YorkshireWater

**Your Ref: 2024/90548**  
**Our Ref: A005108**

**Former Riverside Works, Honley, Holmfirth – Erection of veterinary surgery (Use Class E) and associated works including formation car parking and landscaping**

Appendix H Surface Water Strategy

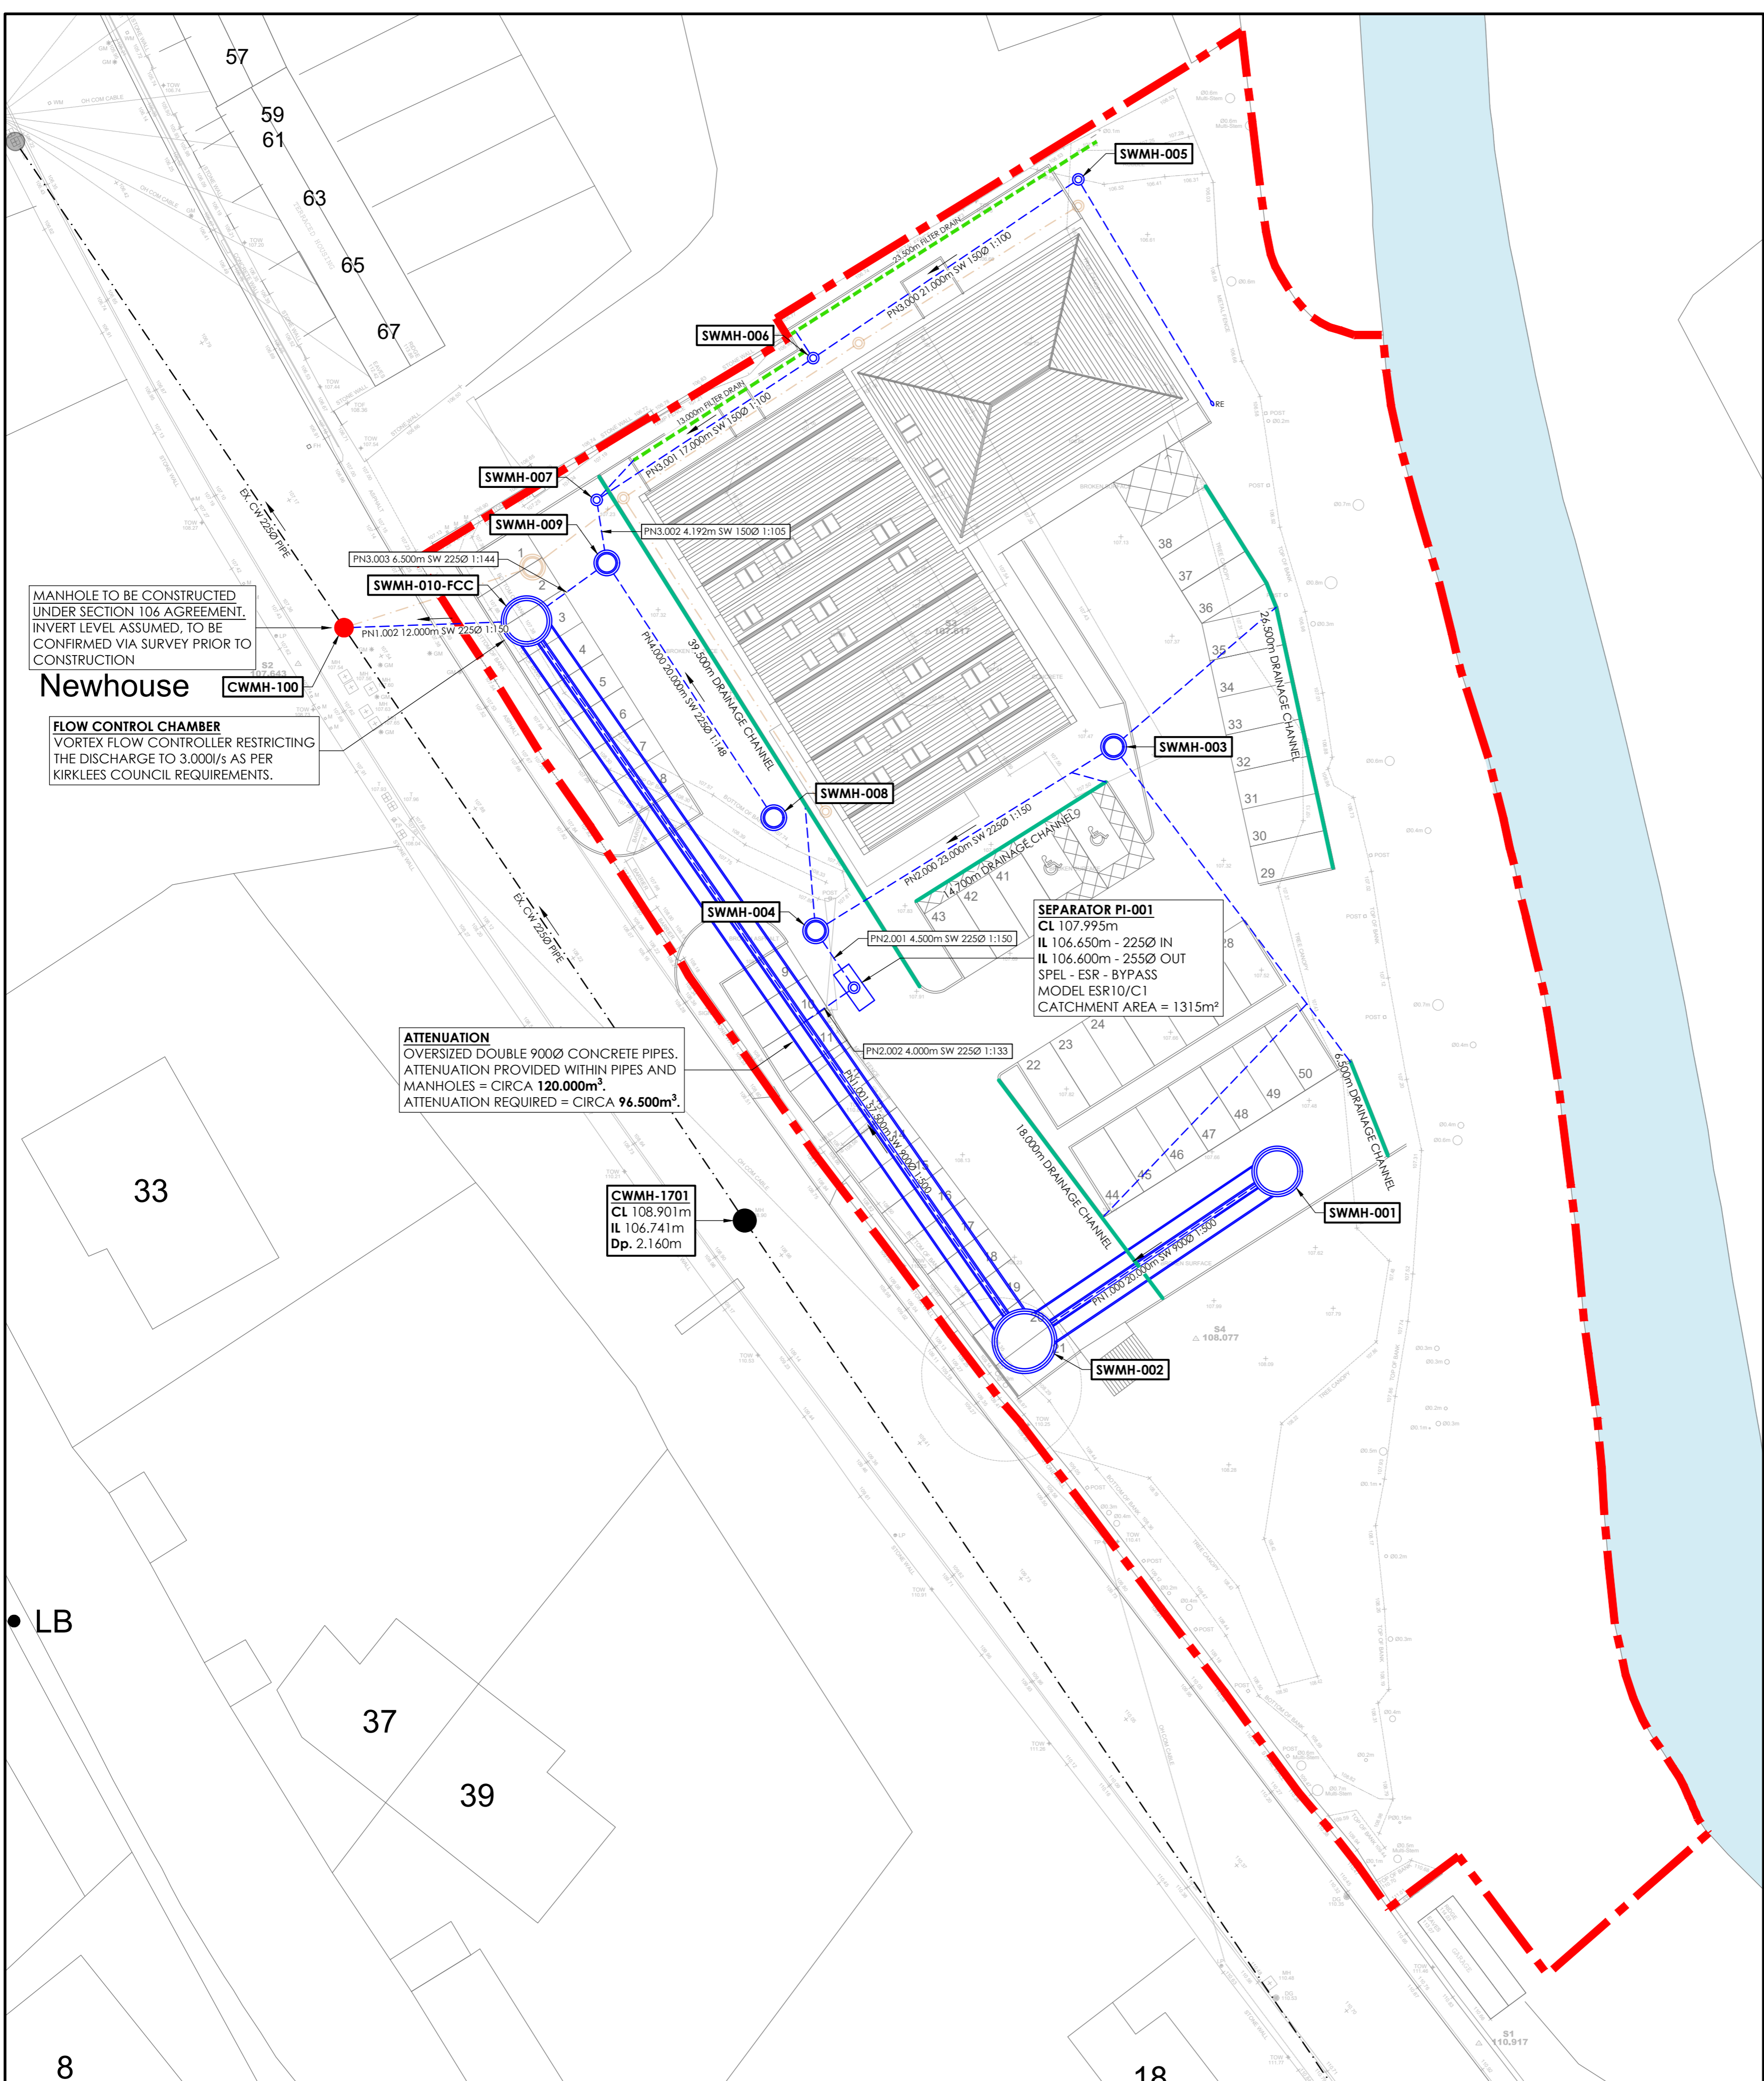
1.) The submitted 'DRAINAGE IMPACT ASSESSMENT' 6369-JPG-XX-XX-RP-D-0621-S2 (rev P02) prepared by JPG, dated 13/09/2024 requires amendments, but if planning permission is granted, the matter can be dealt with via condition.

- a.) Foul water will discharge to public combined water sewer
- b.) Sub-soil conditions do not support the use of soakaways
- c.) A watercourse exists near to the site – discharge has been ruled out due to root protection (subject to advice from LPA – consultation response from LPA on trees does not mention this – please investigate further.
- d.) Surface water will discharge to public combined water sewer via storage with restricted discharge of 3 litres/second.
- e.) The means of surface water management has not been properly considered within the FRA/drainage report. Yorkshire Water requires further information regarding the means of draining surface water from the development

2.) The developer is proposing to discharge surface water to public sewer however, sustainable development requires appropriate surface water disposal.

- a.) Yorkshire Water promote the surface water disposal hierarchy and the developer must provide evidence to demonstrate that surface water disposal via watercourse is not reasonably practical before considering disposal to public sewer.
- b.) The developer and LPA are strongly advised to seek comments on surface water disposal from other drainage bodies as further restrictions may be imposed.
- c.) As a last resort, and upon receipt of satisfactory evidence to confirm the reasons for rejection of other methods of surface water disposal, curtilage surface water may discharge to public combined sewer at a restricted rate not to exceed 3 litres per second.
